H09/1363/01

Description: New shopfront

Location: **16 High Street**
 Holbeach

Re: Application HO9/1363/2001
Proposed Alteration to 16 High Street, Holbeach

SKETCH PROPOSALS

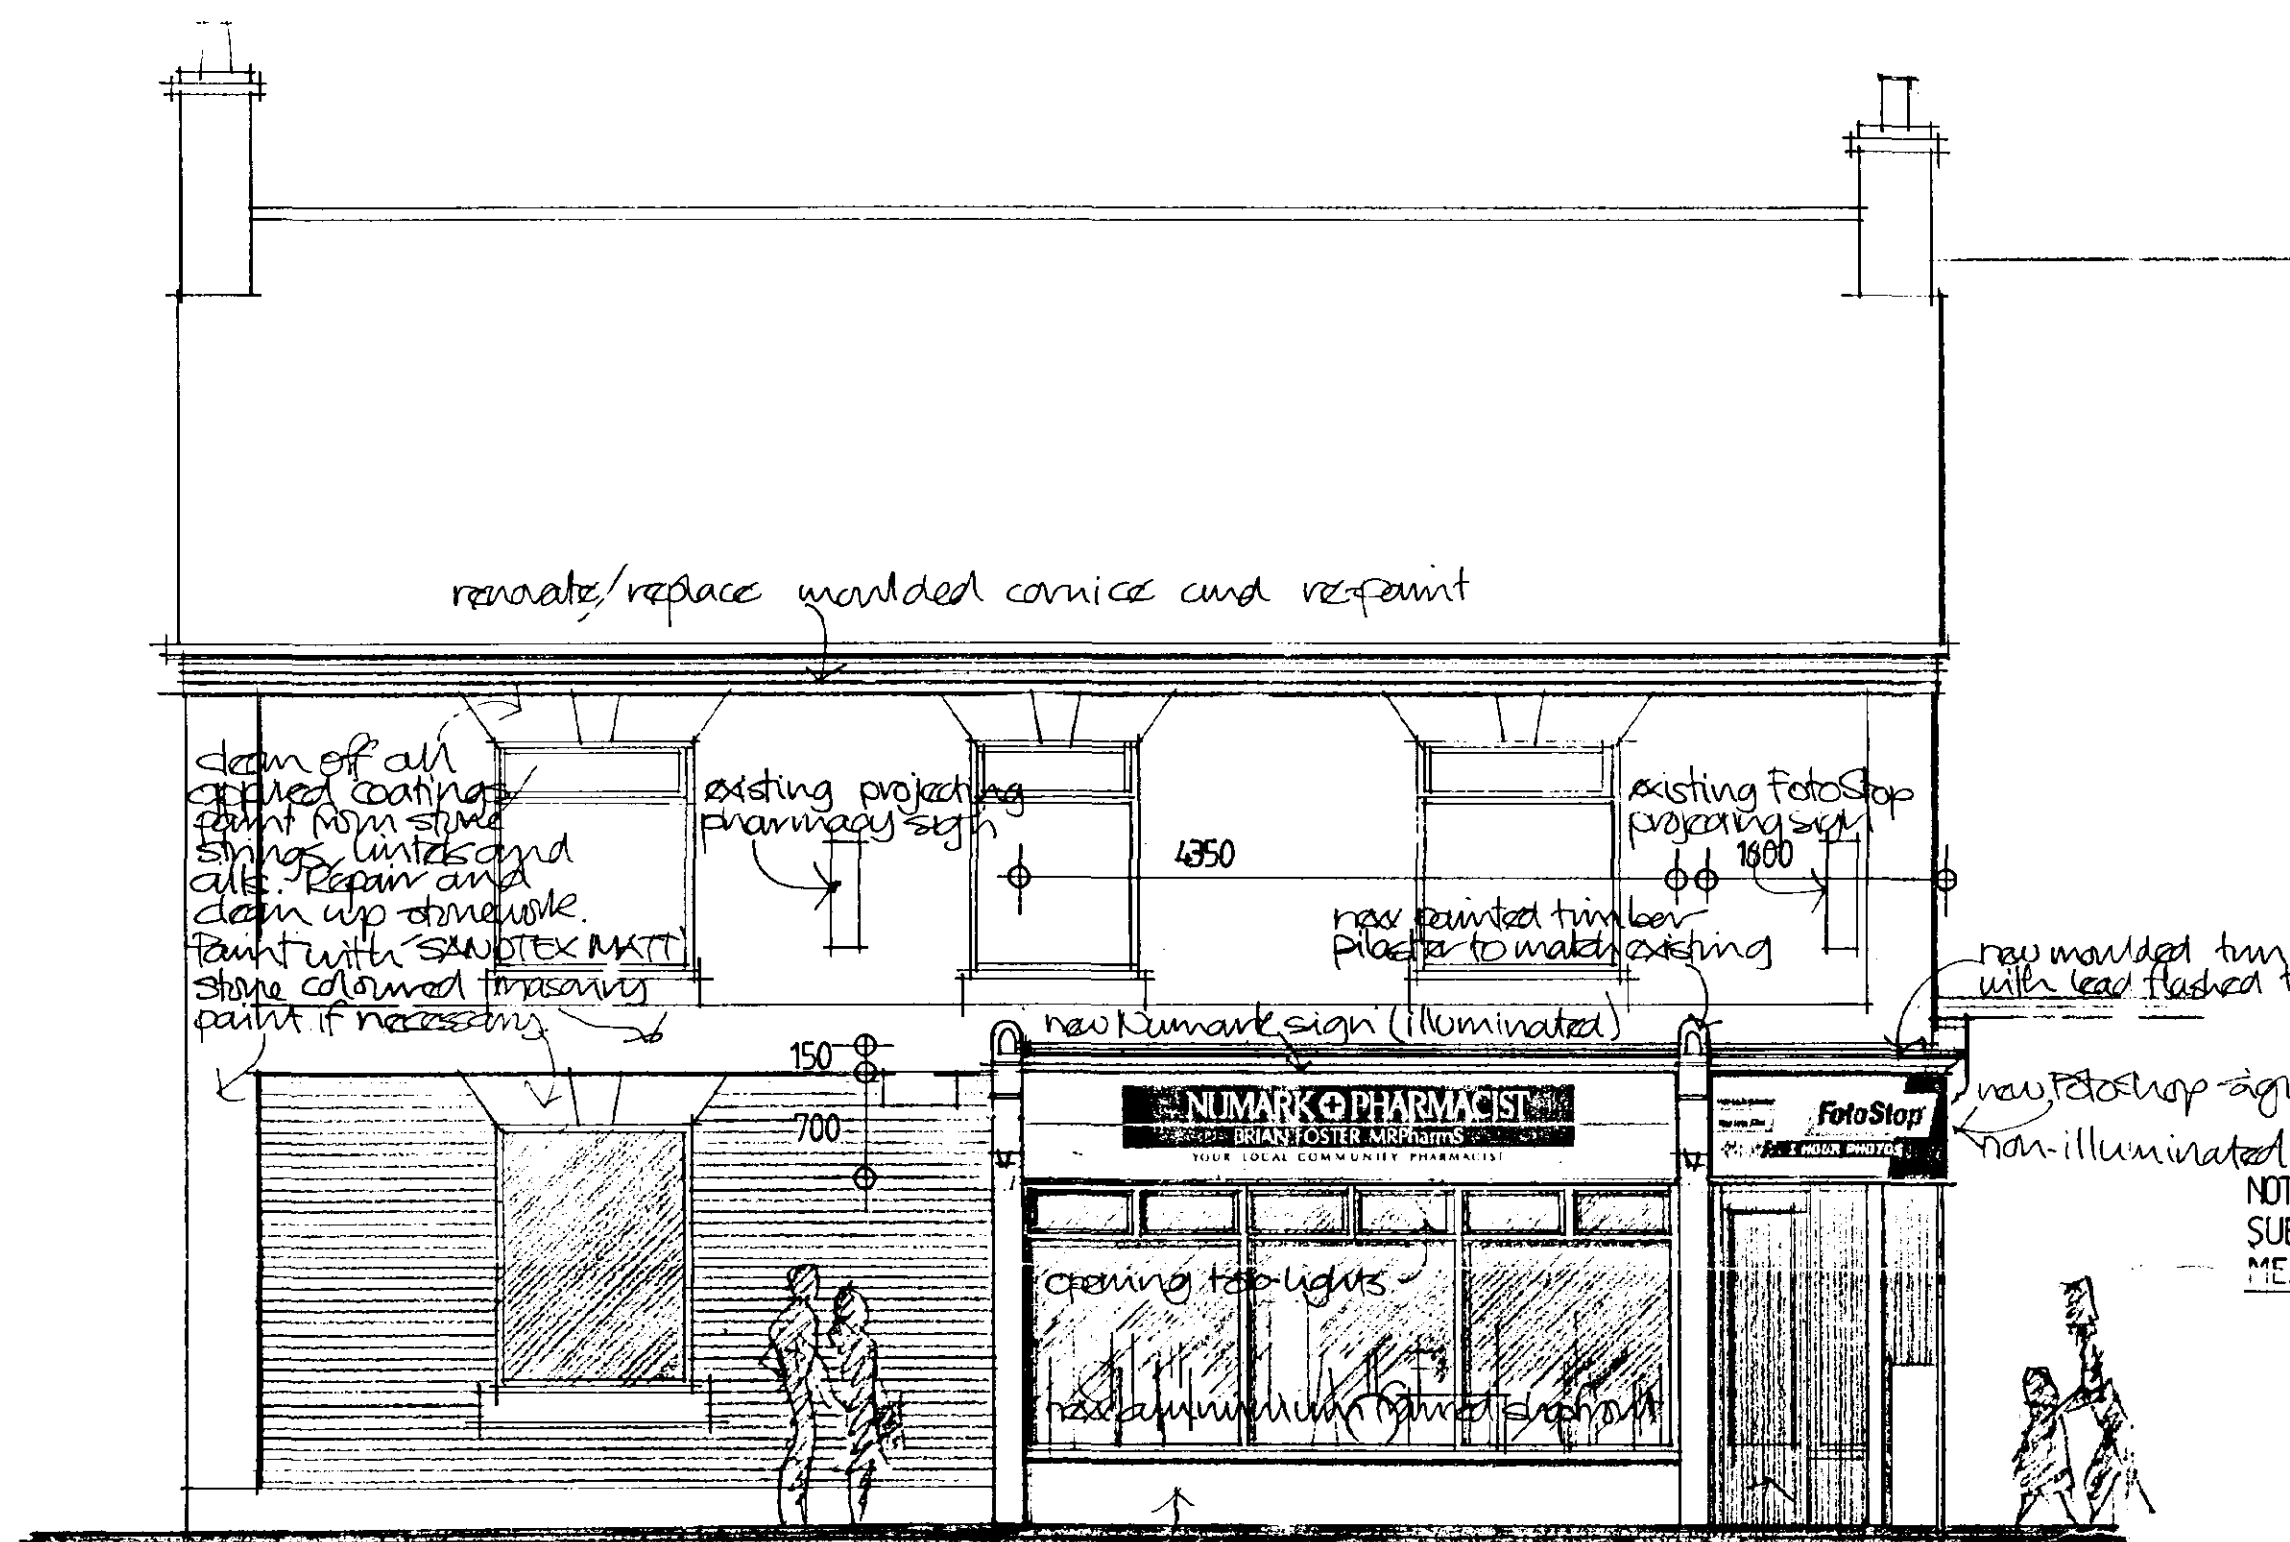
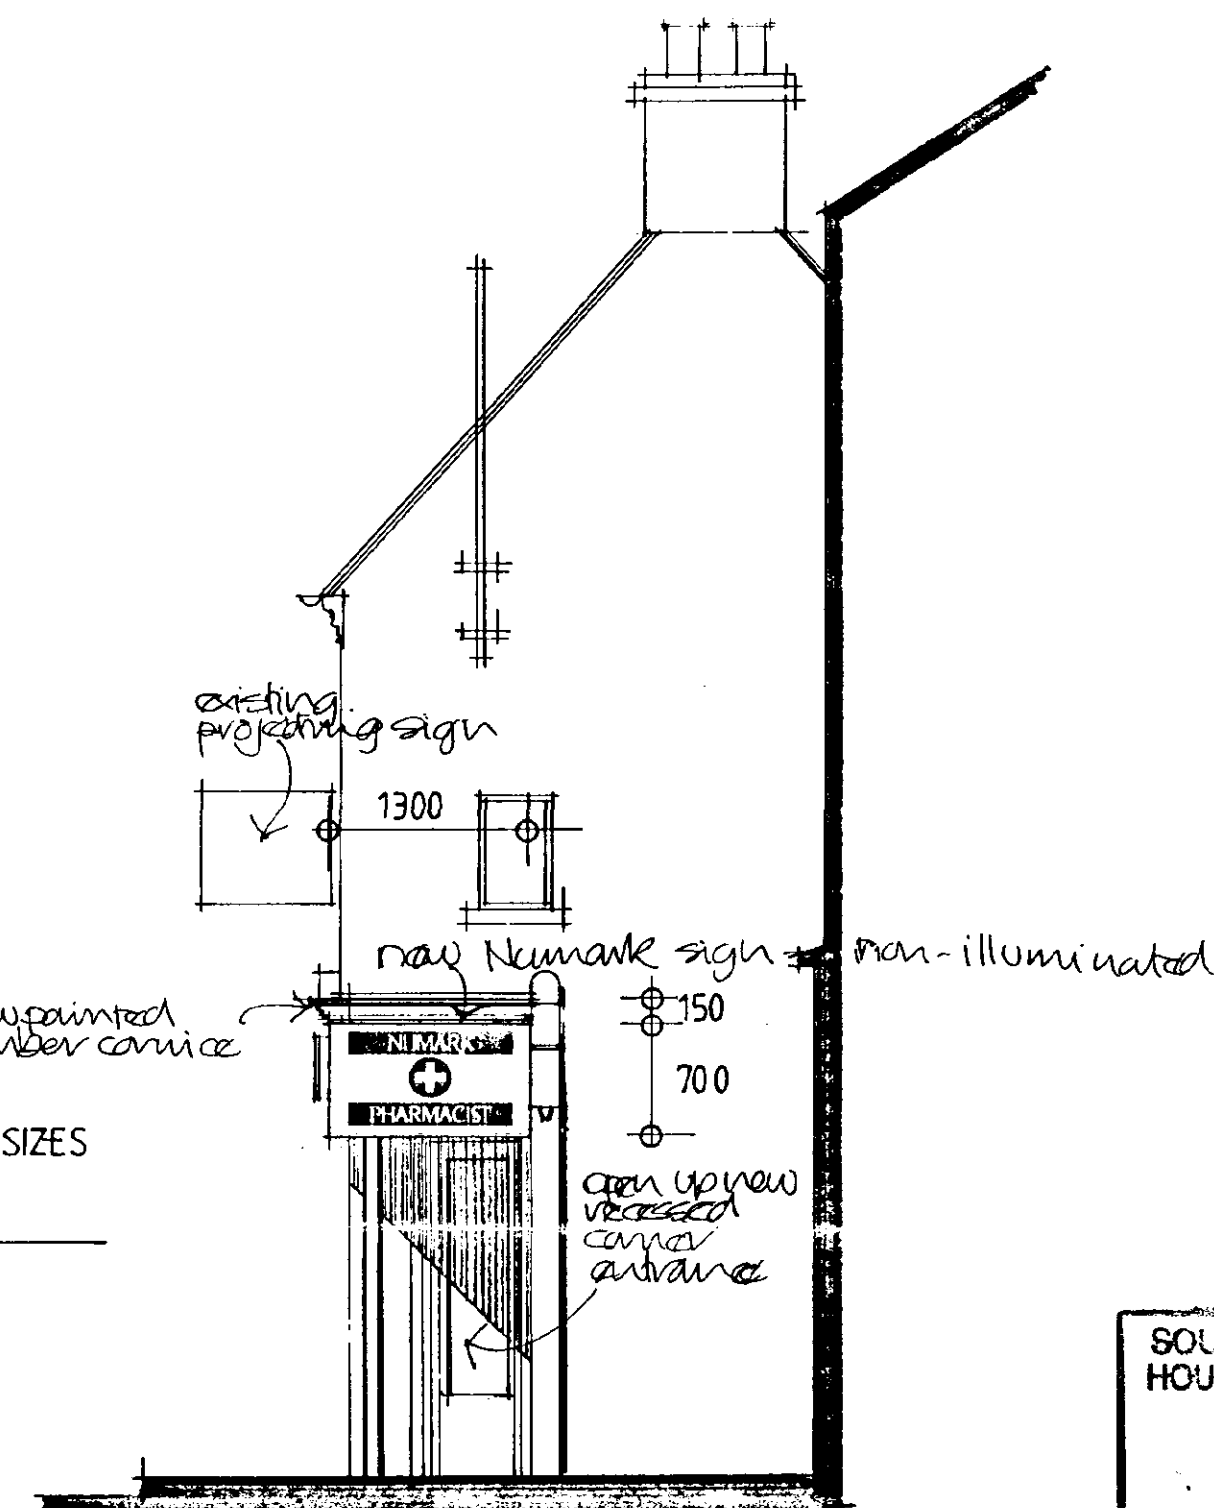
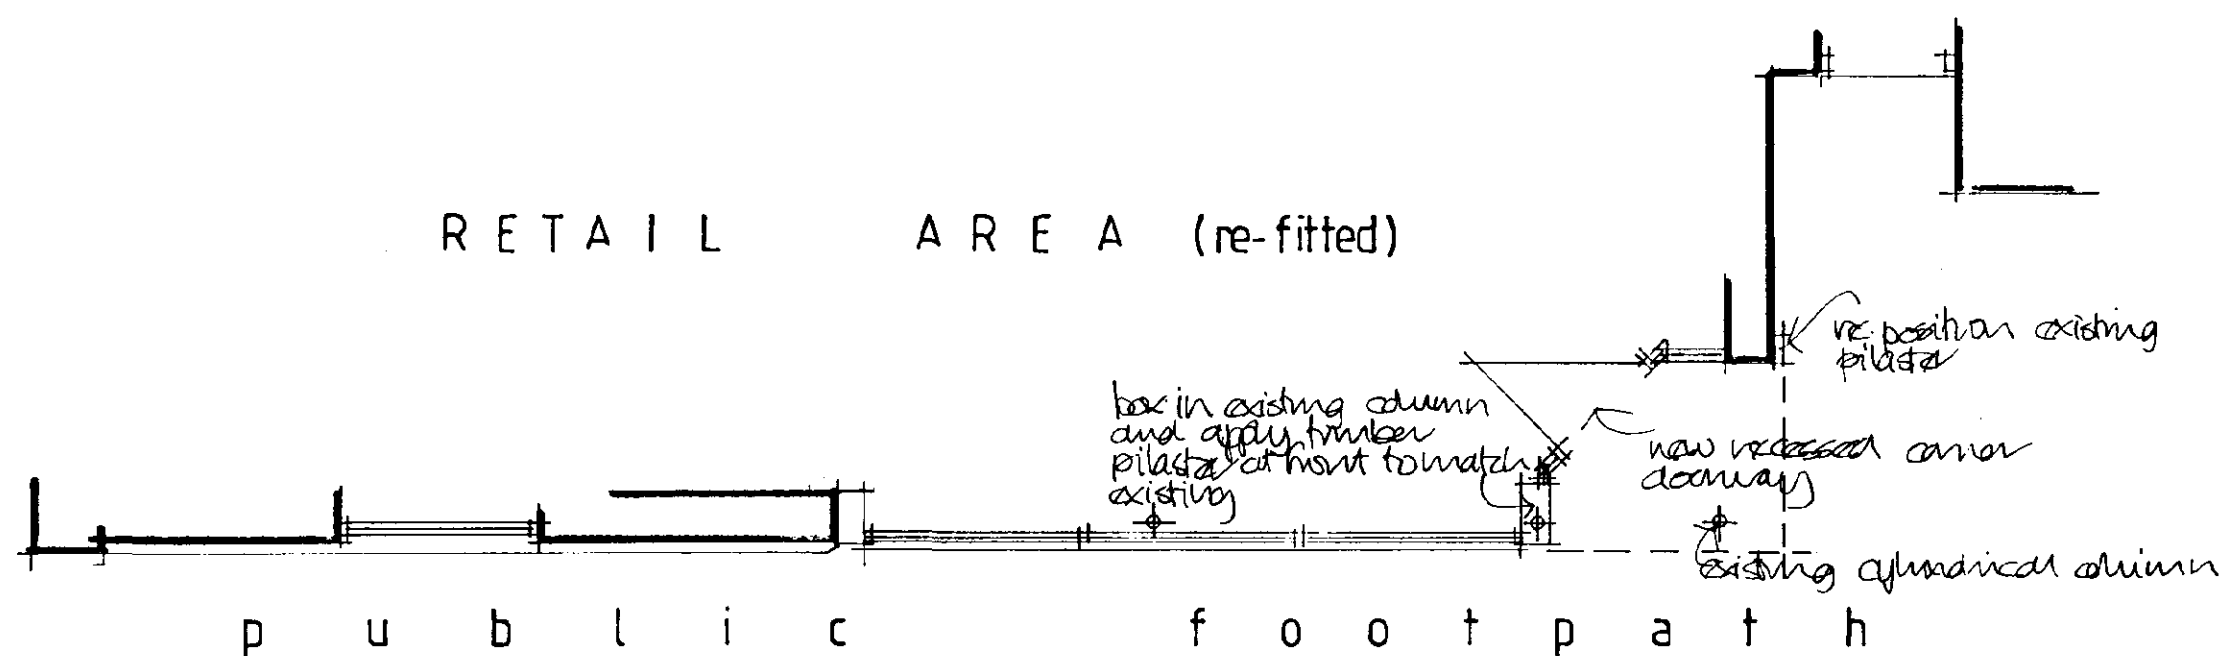
We will accept the new windows in aluminium, providing they use the highest quality, and painted preferably in a cream colour (not white).

There is no mention of shutters in the plans and we wonder if they are still to be used?

Concerning the new shop front, South Holland District Local Plan Policy E7 states that replacements should be constructed in materials compatible with the building upon which they are situated. Further, supplementary planning guidance relating to Holbeach Conservation Area stipulates that shop windows generally should use painted wood as their framing material and that they should be of a scale and type which is in keeping with the age and style of the building itself.

The building in question is of traditional appearance (probably Georgian). Although the present fenestration is not of original design it is nevertheless timber, including the shop front. It is therefore considered that the replacement shop windows should be constructed in timber and not aluminium as proposed. This would also ensure that it remained sympathetic with existing shop fronts to the west.

Finally, it is assumed that the lettering and logos only will be illuminated on the proposed "Numark Pharmacist" fascia signs. Please confirm.

As this pharmacy is in the Conservation Area, we would have preferred the new windows to be inserted in wood, rather than the use of aluminium.

We notice the new Newmark Pharmacist sign is to be illuminated - this should be each letter or symbol individually illuminated or situated on an opaque background, see page 4.6 Supplementary Planning Guidance, Holbeach Conservation Area.

shop front will have a timber surround. Frame itself will be colour coated (cream) aluminium. Will not harm character/appearance of conservation area when compared with what existing, which include, aluminium shutters. Visual appearance compatible.

② The new pilasters and cornice shall be constructed in timber.

③ The new window frame shall be constructed in colour coated aluminium, with a clean finish.

② The applicant is advised that the installation of shutters ~~and~~ and/or blinds will require further planning permission.

I can confirm that only the lettering and logos will be illuminated on the Numark fascia sign, although there will be a "halo" around the projecting portion of sign, and a small illuminated line either side of the lettering, as shown on the night-time photograph submitted with the application.

Secondly, I confirm that we would like to retain our intention to use aluminium for the shopfront frame, partly since we are considering a shopfront system that includes an automatic entrance door, and this is made difficult if we are to use timber. I also accept however that you may prefer to retain a painted timber frame from an authenticity point of view, but the overall design for the new shopfront and signage is such a marked improvement upon the existing situation that I feel a degree of compromise has to be appropriate.
